TOWN OF ADDISON
 BUILDER'S COPY OF PLANS
 This set of plans contains various corrections and comments
 made by the City Staff. All trades will be required to comply
 with these corrections and comments. Failure to inform
 all trades of this information will not be accepted as a reason
 to approve construction which is in violation of local
 ordinances.
 This set of plans is to be kept on the job site at all times
 and is to be made available for use by city inspectors at
 their request. Failure to have these plans available may
 delay approval of a requested inspection.

01 FIRST FLOOR PLAN - PLUMBING
 P2.1

**ADDITION TO
 PUBLIC WORKS SERVICE CENTER**
 Westgrove Road
 Addison Texas

SHEET NO.
P2.1
 OF SHEETS
 JOB NO: 851-137

**EDI ARCHITECTS, INC.**  
 ARCHITECTURE PLANNING ENGINEERING INTERIOR DESIGN  
 6440 WALNUT HILL LANE  
 SUITE 100 DALLAS, TEXAS 75201  
 972-486-8308

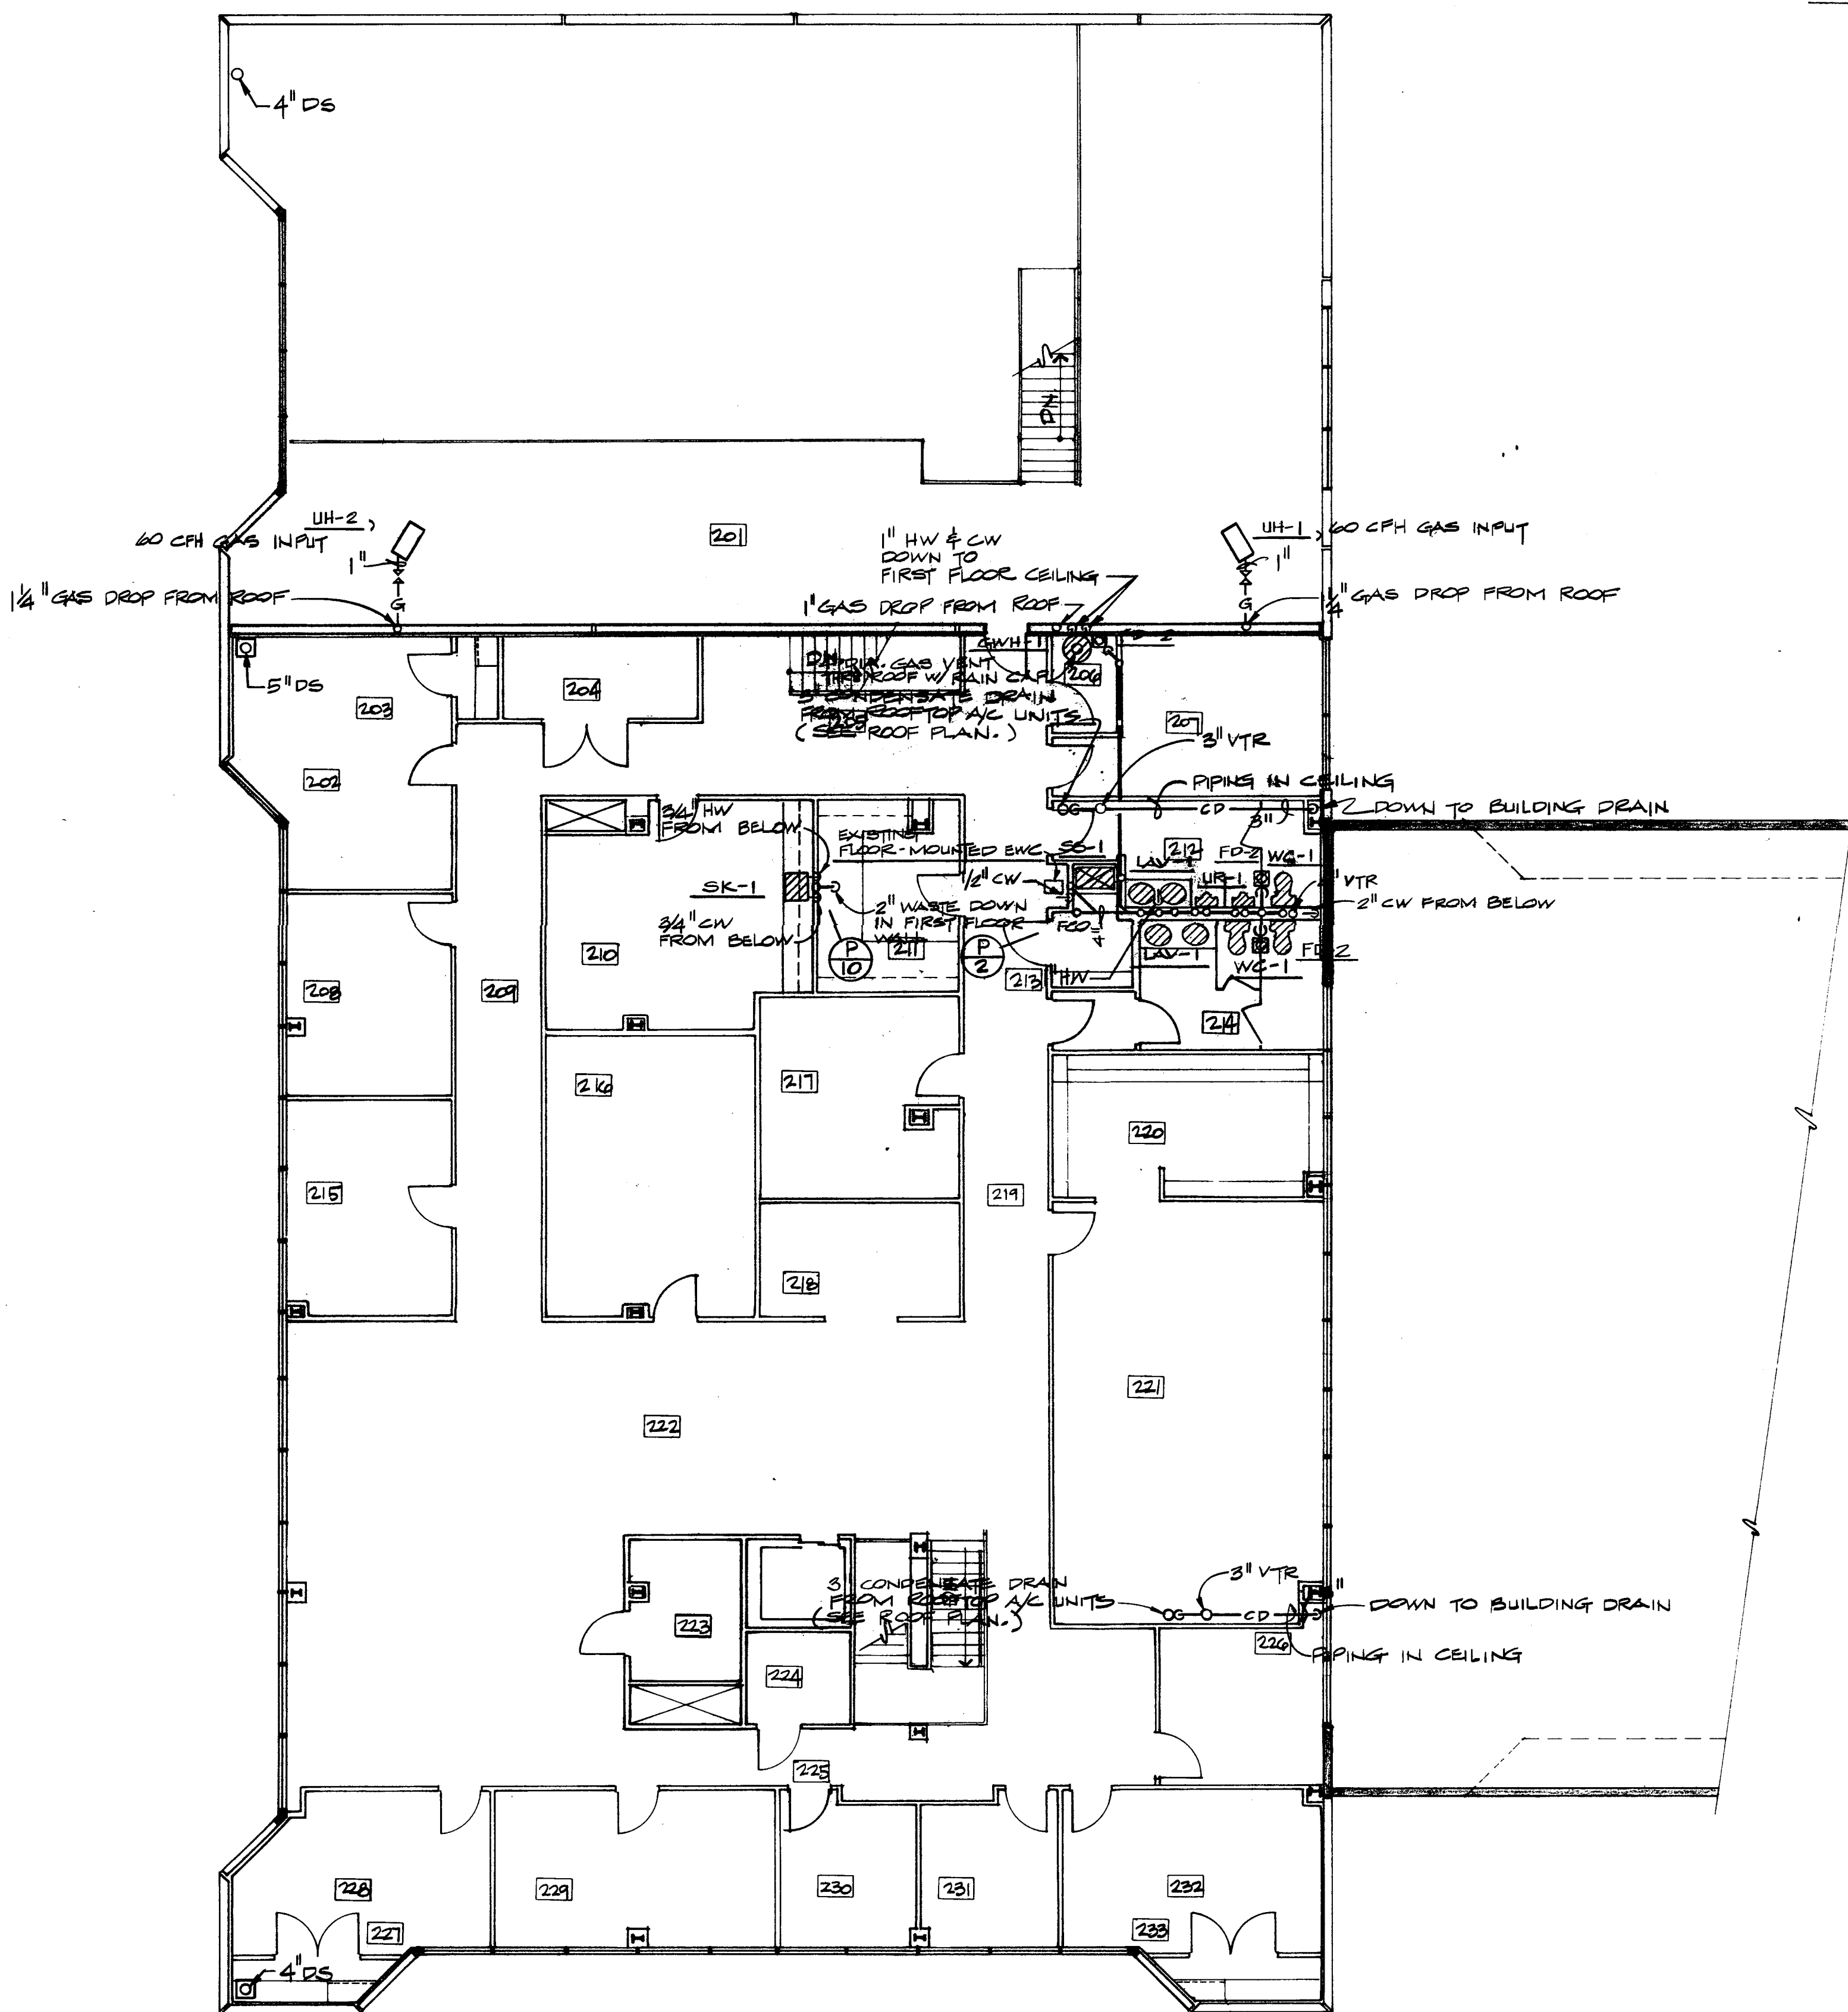
PLUMBING ISSUED IN FULL SCALE CONTRACTS
 NO UTILITIES TO BE
 INSTALLED UNTIL THE
 FOLLOWING PLANS ARE SUBMITTED
 AND APPROVED BY ENGINEER
 AND UTILITY COMPANIES.

1. COMPLETE SITE PLANS
2. P-1 (REVISED PLUMBING PLANS)
3. SITE UTILITY PLANS
4. SITE LAYOUT PLANS

1. SUBMIT ROOF DRAIN/STORM SEWER PLANS
2. EX. EL. PIPES & COMM. SEWER PLANS
3. SIZE & TYPE PIPE GRADES

1. STACK ALL PLUMBING.
2. KEEP SANITARY AND STORM SEPARATE.
3. ALL DRAINS IN GARAGE AND CLEAN UP AREA MUST GO THROUGH THE SAND TRAP, SAND TRAP TIES TO SANITARY.
4. AREA DRAINS FOR VEHICLE CLEAN UP MUST BE UNDER COVER.
5. SMALLEST FLOOR DRAIN, AREA DRAIN, IN HUB DRAIN ALTHOUGH IS 3" MAIN LINE SHOULD BE MIN. OF 4".
